Department of Primary Industries

OUT14/12950

8 MAY 2014

Googong Water Cycle Project (MP08_0236 Mod 2) Proposed Modification

Figure 3 Proposed layout for discharge pipeline

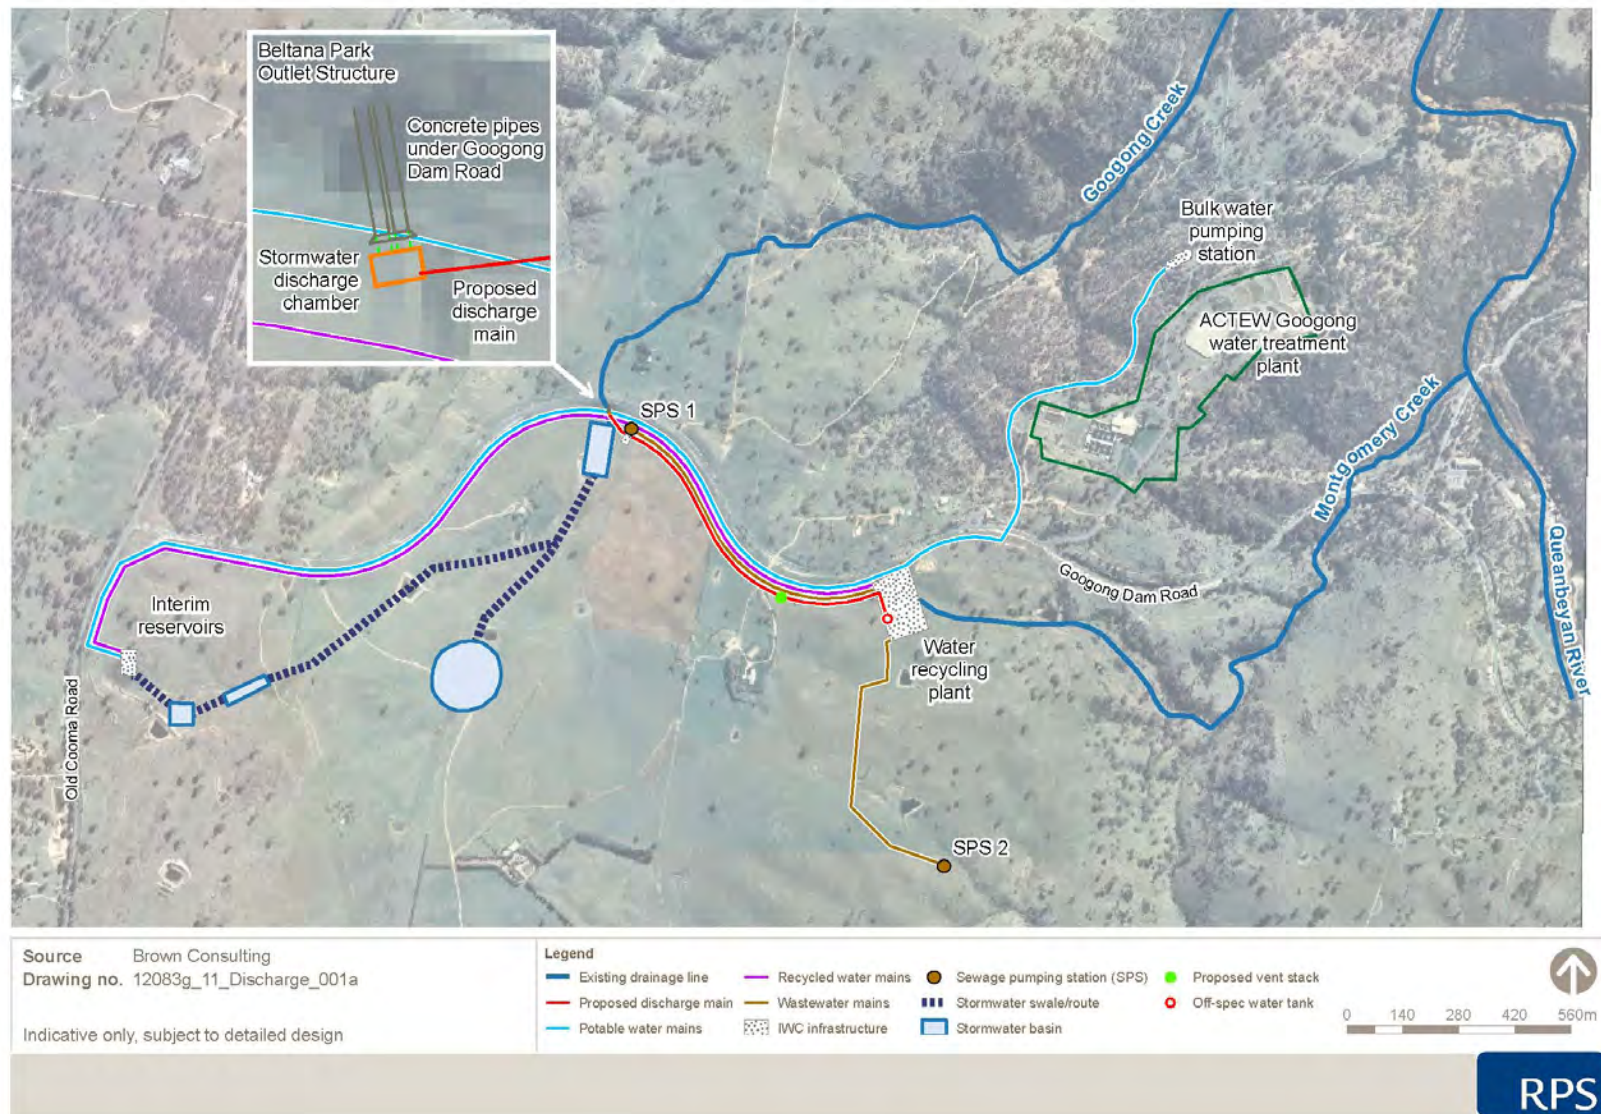
- It is recommended the design and construction of the discharge location and works within 40m of the watercourse be carried out in accordance with the NSW Office of Water "*Guidelines for Controlled Activities on Waterfront Land*". These guidelines can be accessed at the following link:
<http://www.water.nsw.gov.au/Water-Licensing/Approvals/Controlled-activities/default.aspx>.
- It is recommended water quality downstream of discharge point 3 be monitored to aid in minimising impacts to the aquatic environment and downstream water users. The development of contingency options is recommended to mitigate potential impacts. It is recognised an Environment Protection Licence (EPL) will be required to regulate the water quality of discharged recycled water.
